Subject: RE: Inglenook P/58/19/PL

For completeness, my report update summarises the main points of the Transport Review as being:

Visibility Splays and Internal Swept Path Analysis

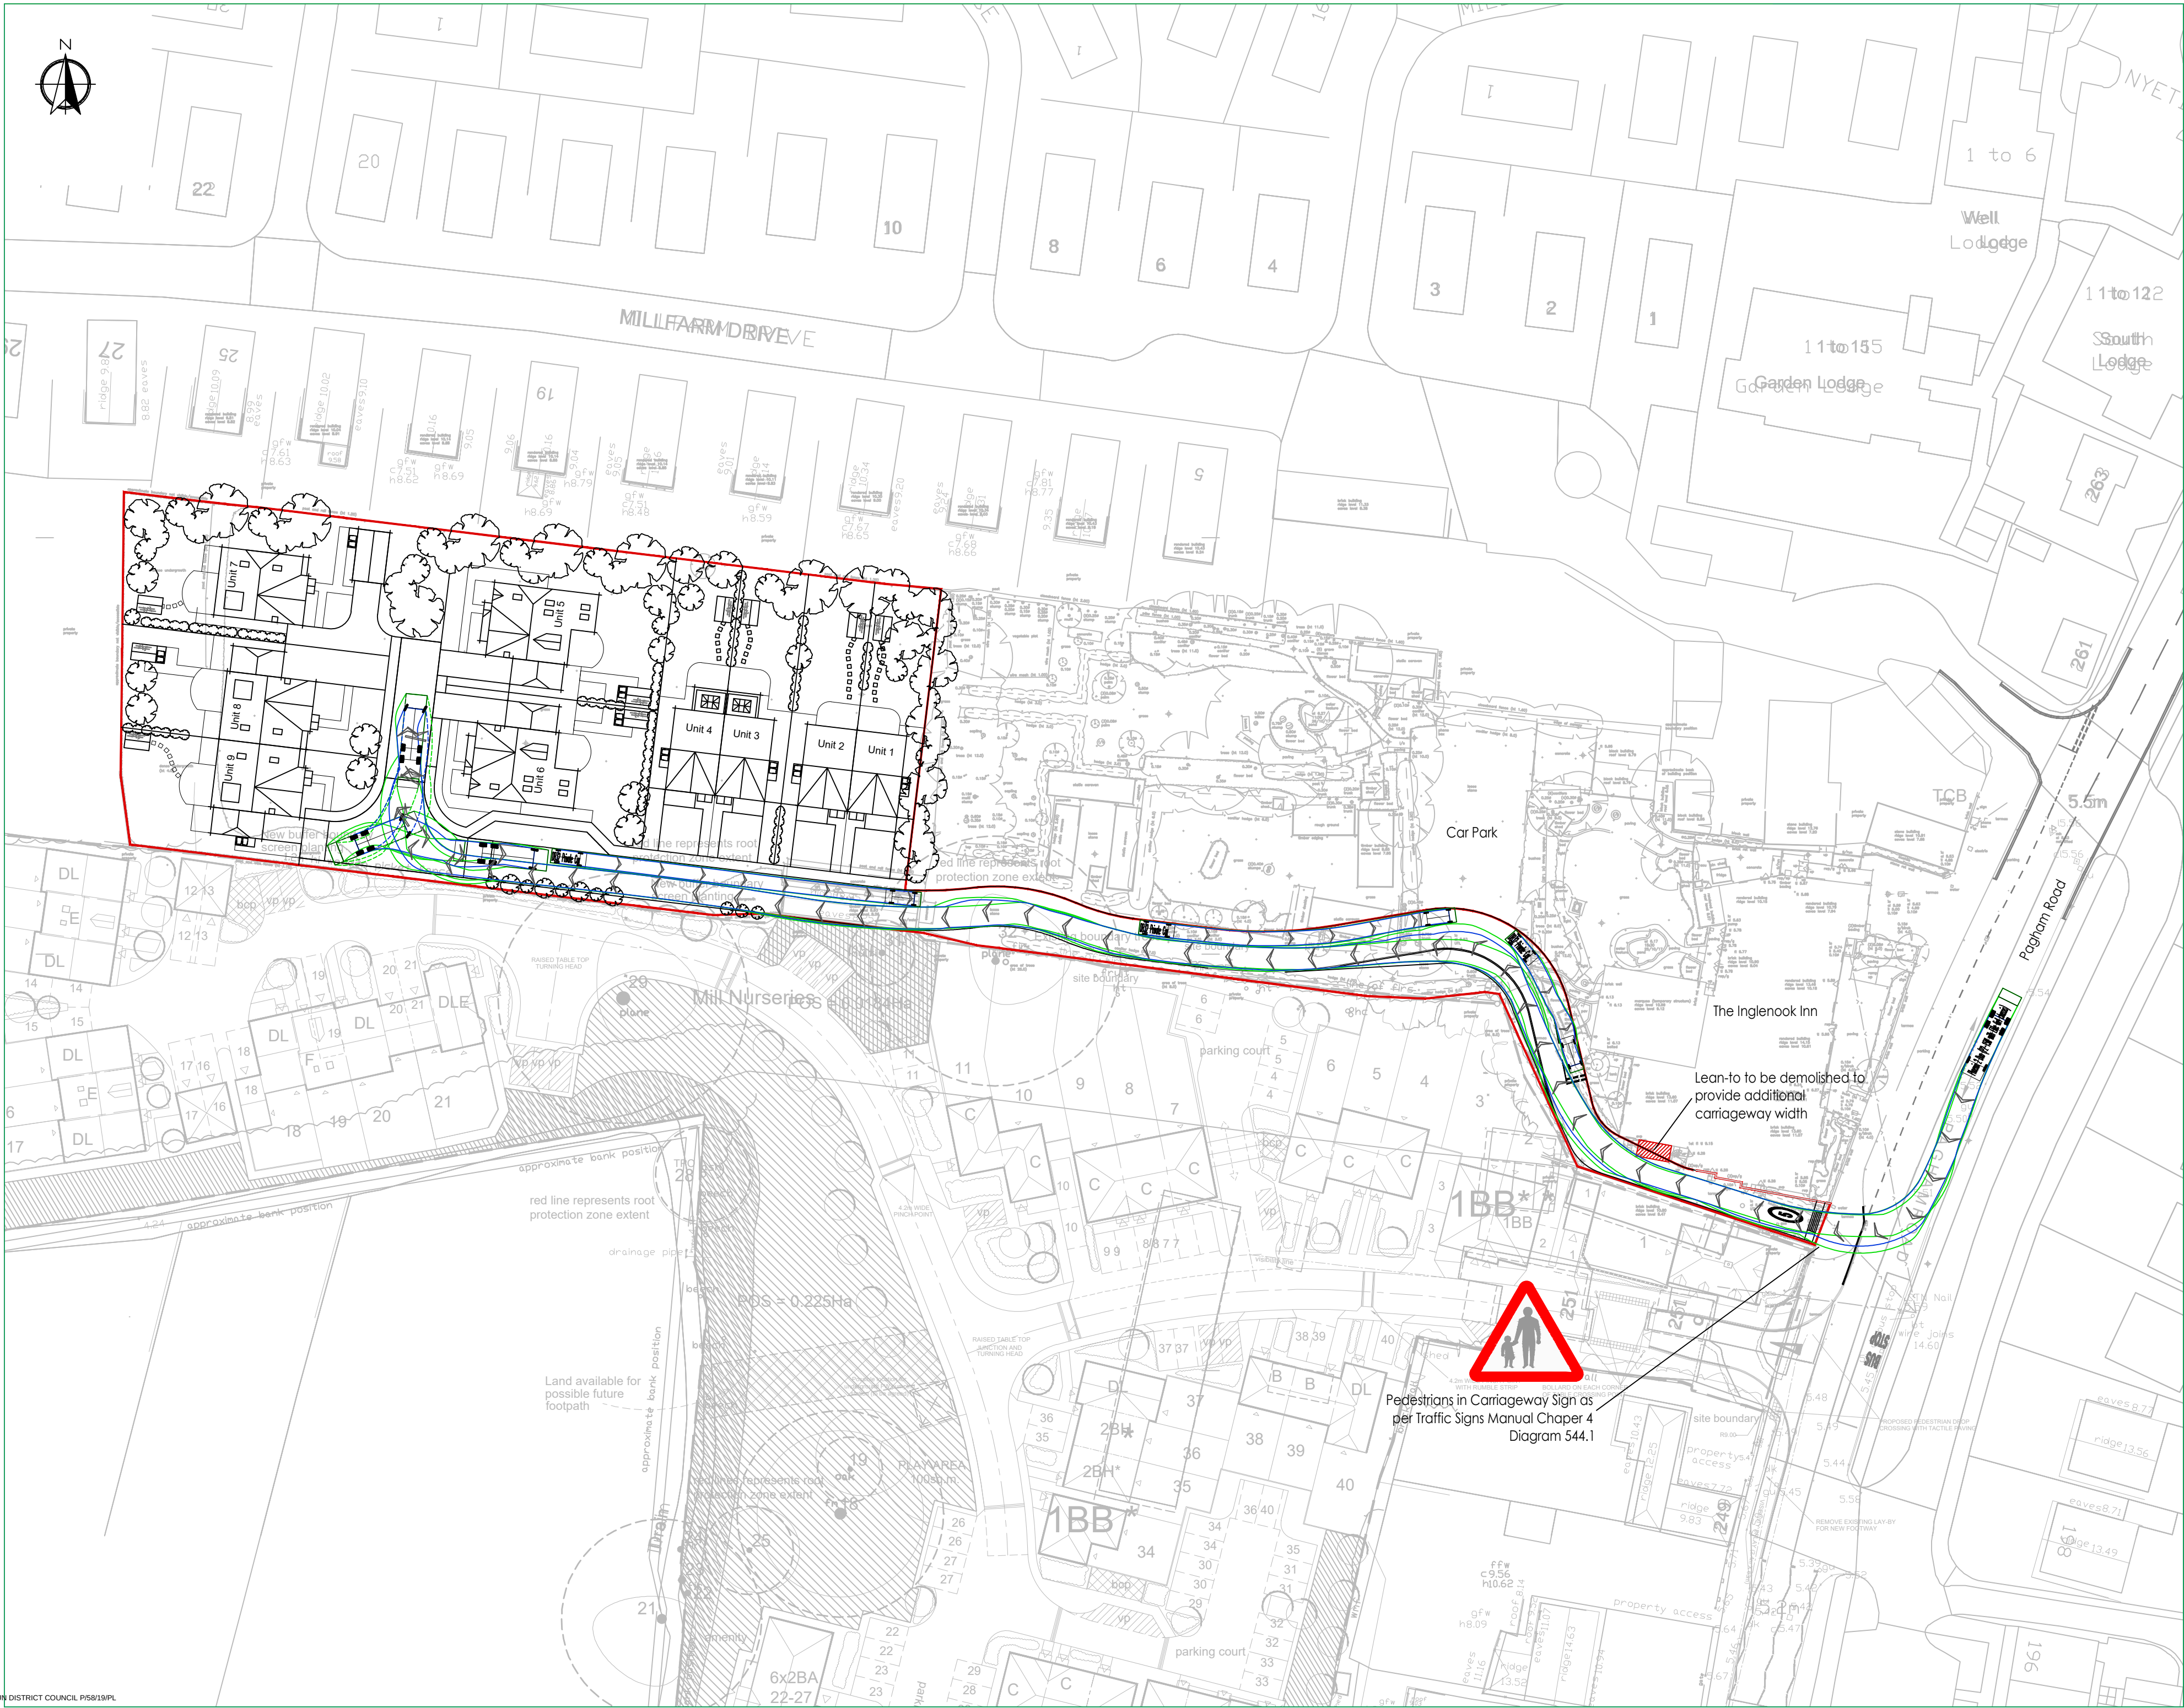
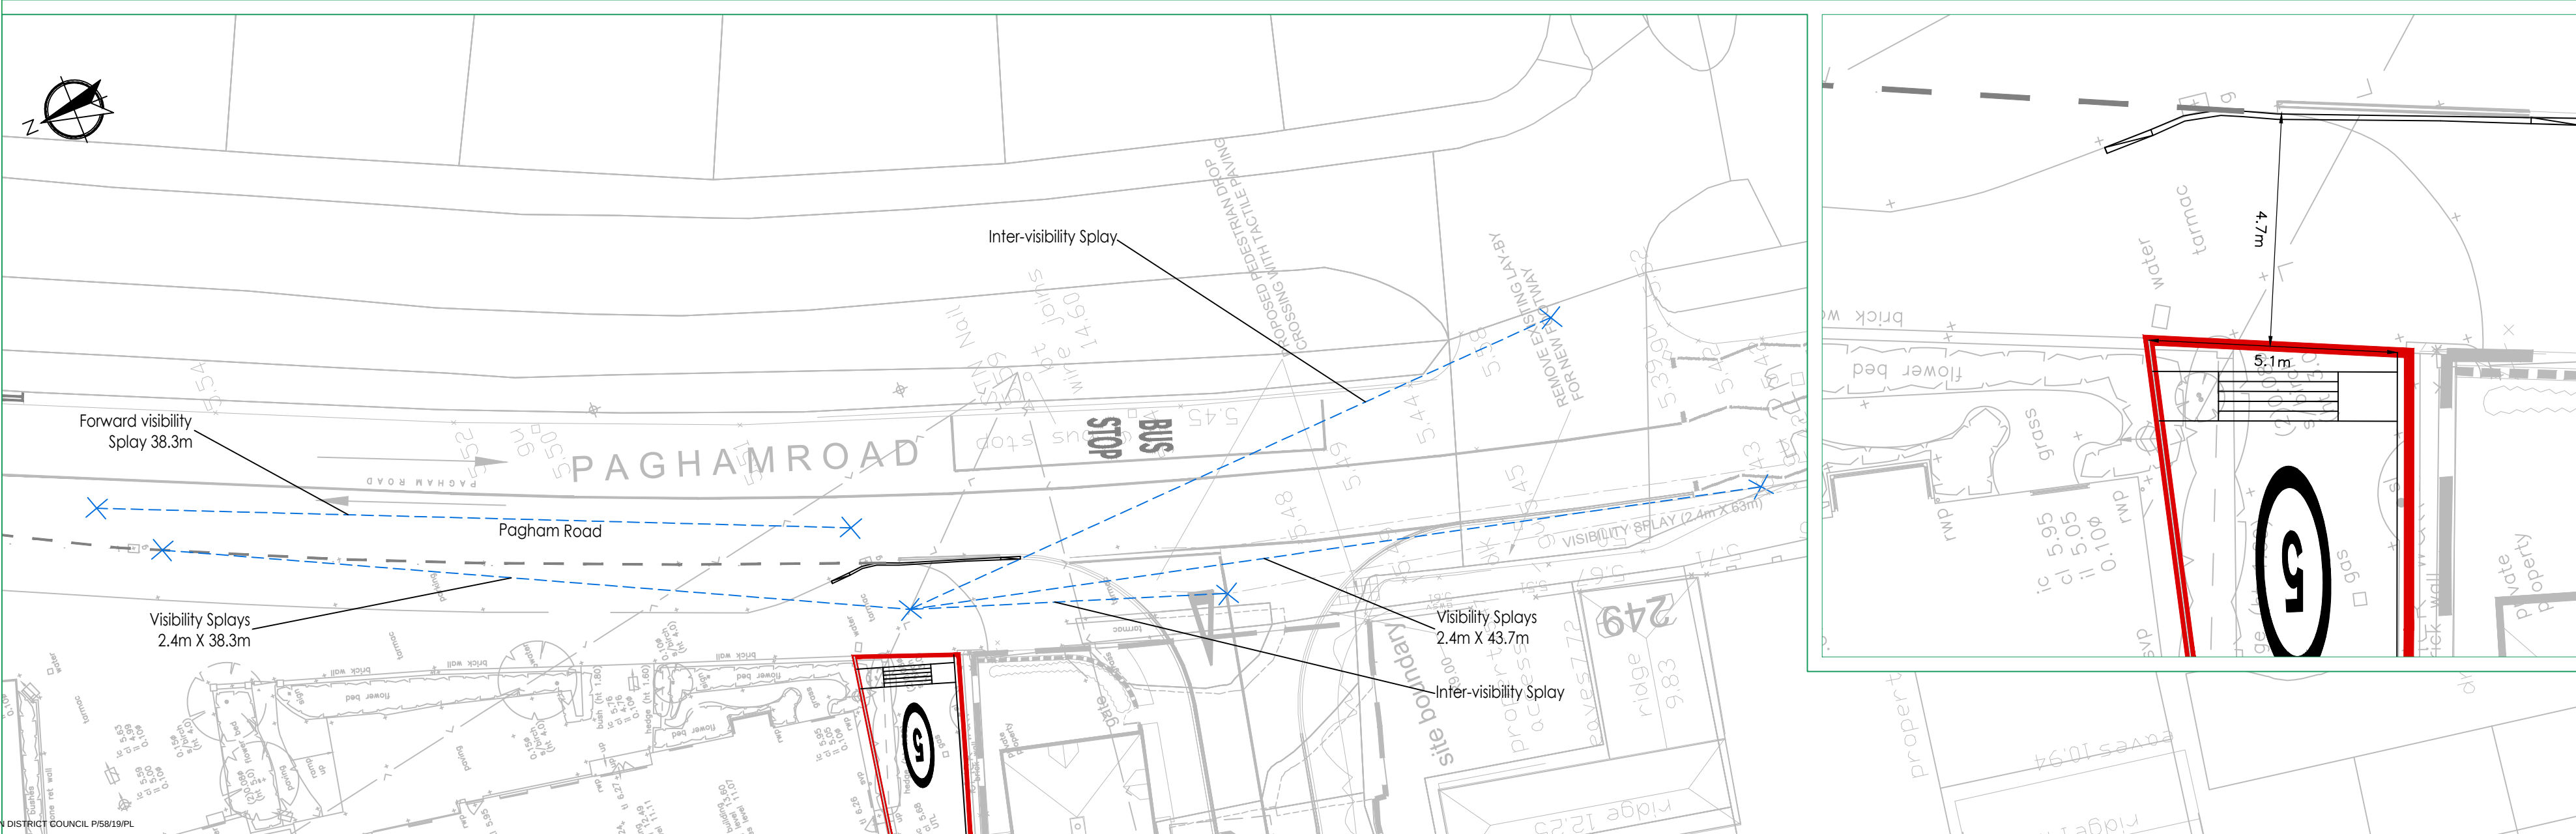
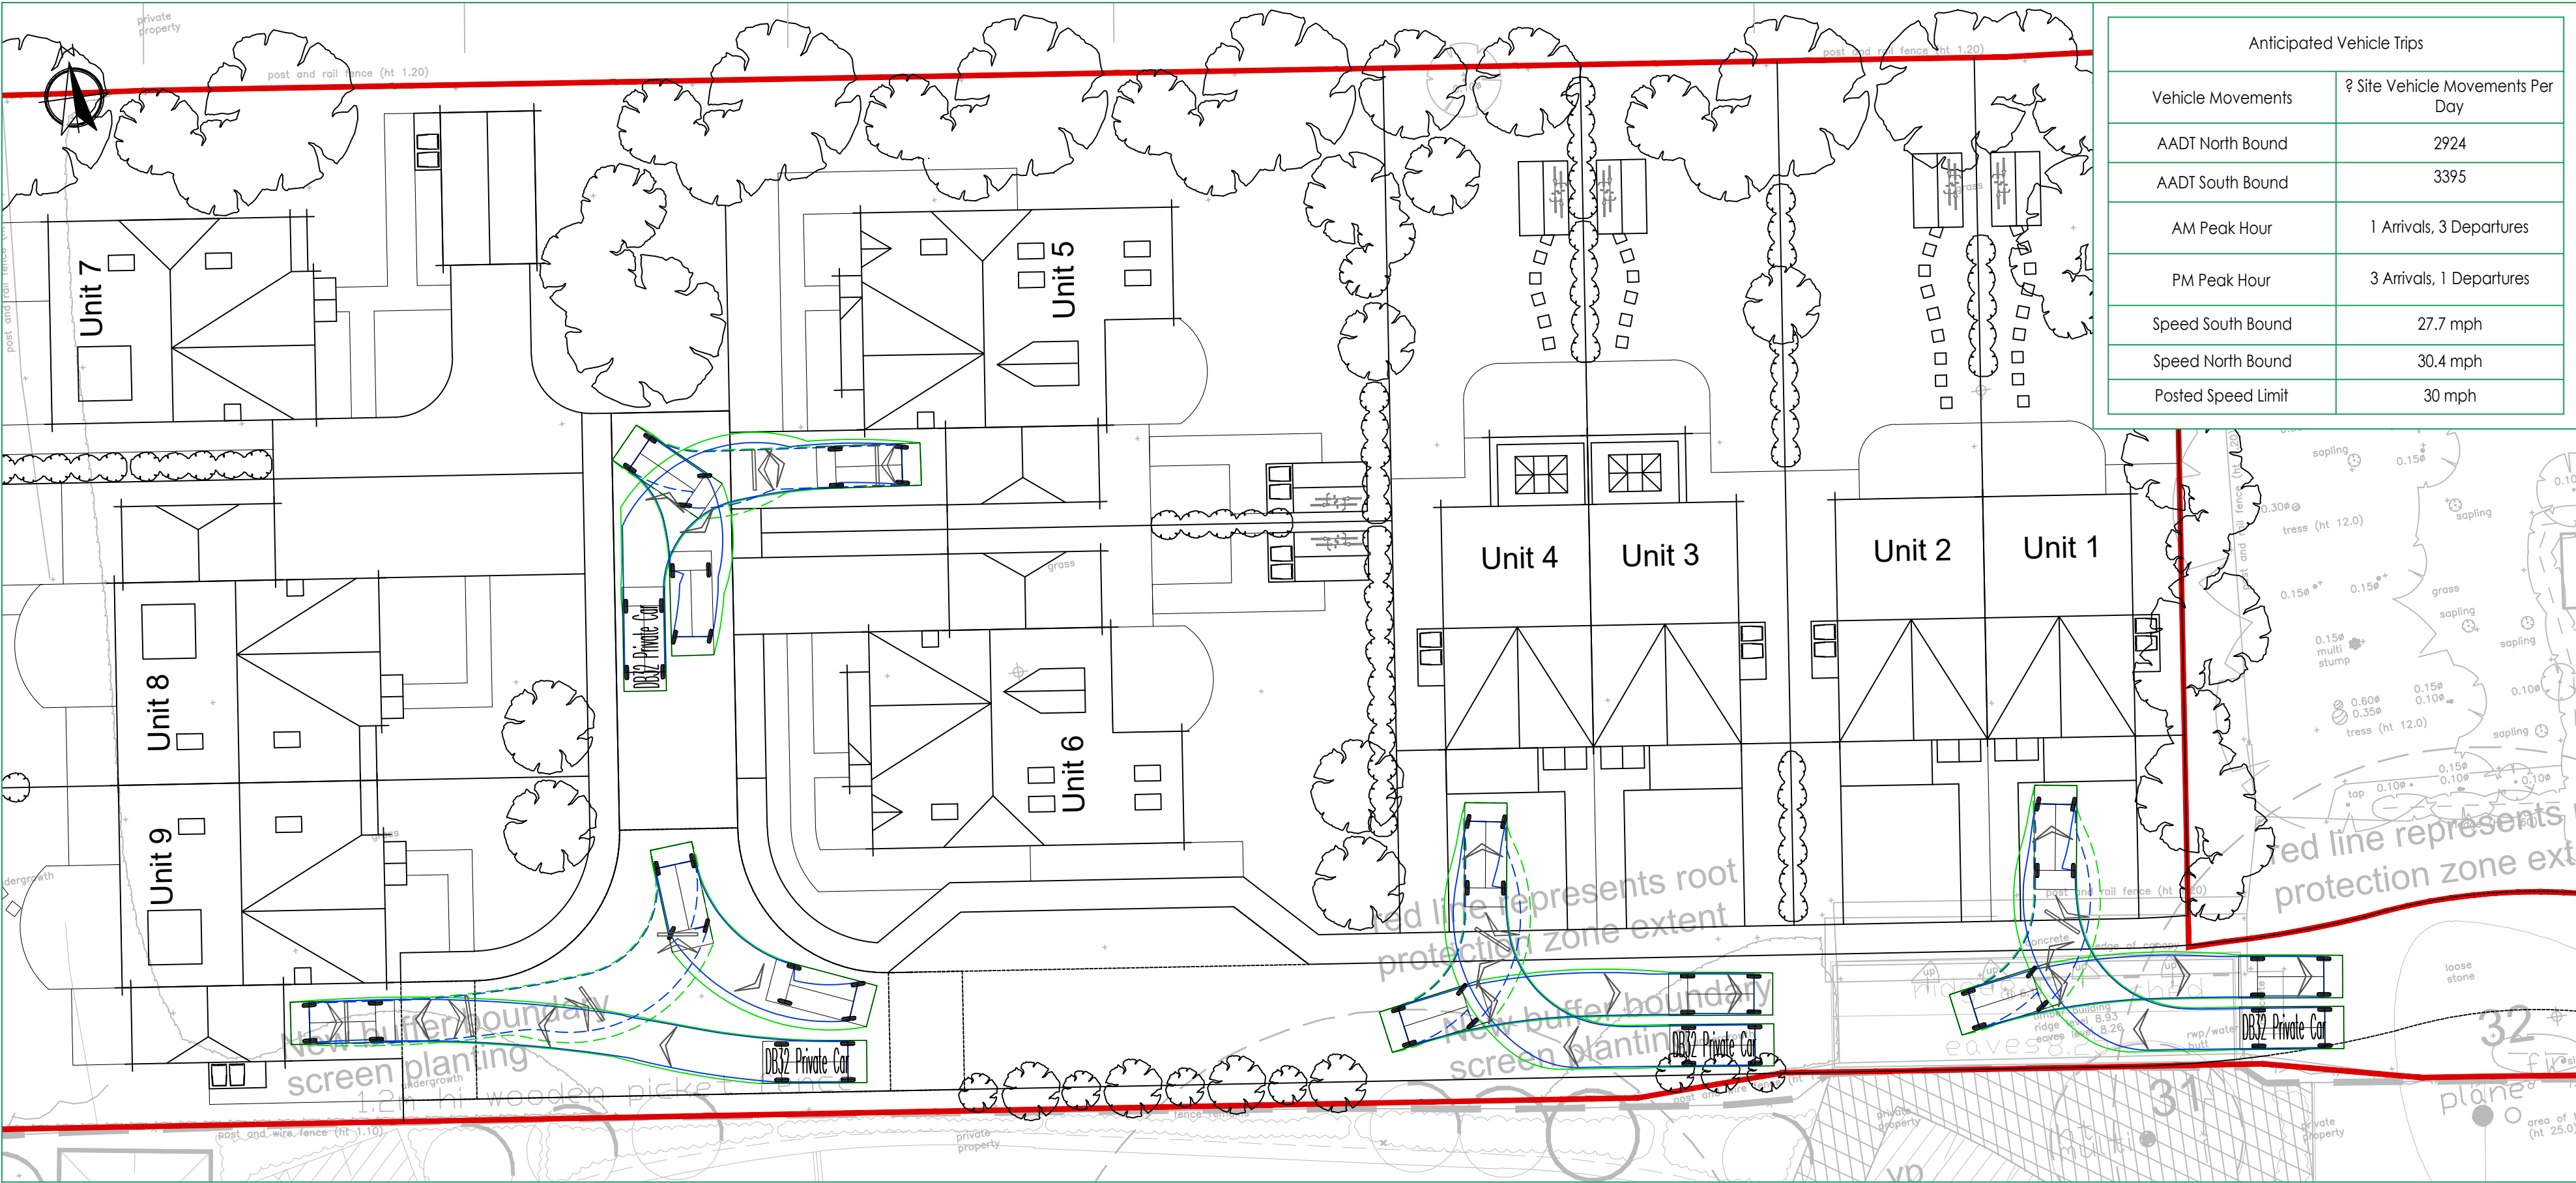
- There does seem to be a trend with collisions at junctions within the area that may present further issues with increased levels of traffic;
- The swept path analysis doesn't take account of any parked vehicles on Pagham Road. There are currently no restrictions and a refuse vehicle would not be able to make a turn with the present arrangements without parking restrictions reducing the existing availability for residents and visitors on-street;

- Manual For Streets (MfS) does suggest that occasional parking in visibility splays is quite common but defined bays should be provided outside visibility splays. The presence of the layby to the north will have a significant impact to the safety with the additional flow expected from the development at peak times (particularly if a high sided vehicle is present in the layby);

- The swept path analysis of the narrowest part of the access road is very close to lamp columns and steps with no margin of error;
- The additional trips are unlikely to have a detrimental impact to the transport network in the vicinity of the site; and

(13) No development above damp proof course (DPC) level shall take place until there has been submitted to, and approved by, the Local Planning Authority, a scheme of signage/visual measures to alert drivers entering the access from Pagham Road of the potential for pedestrians to be in the road. No part of the development shall be occupied unless and until the approved measures have been provided in full. Thereafter, these features shall be permanently retained as fit for purpose.
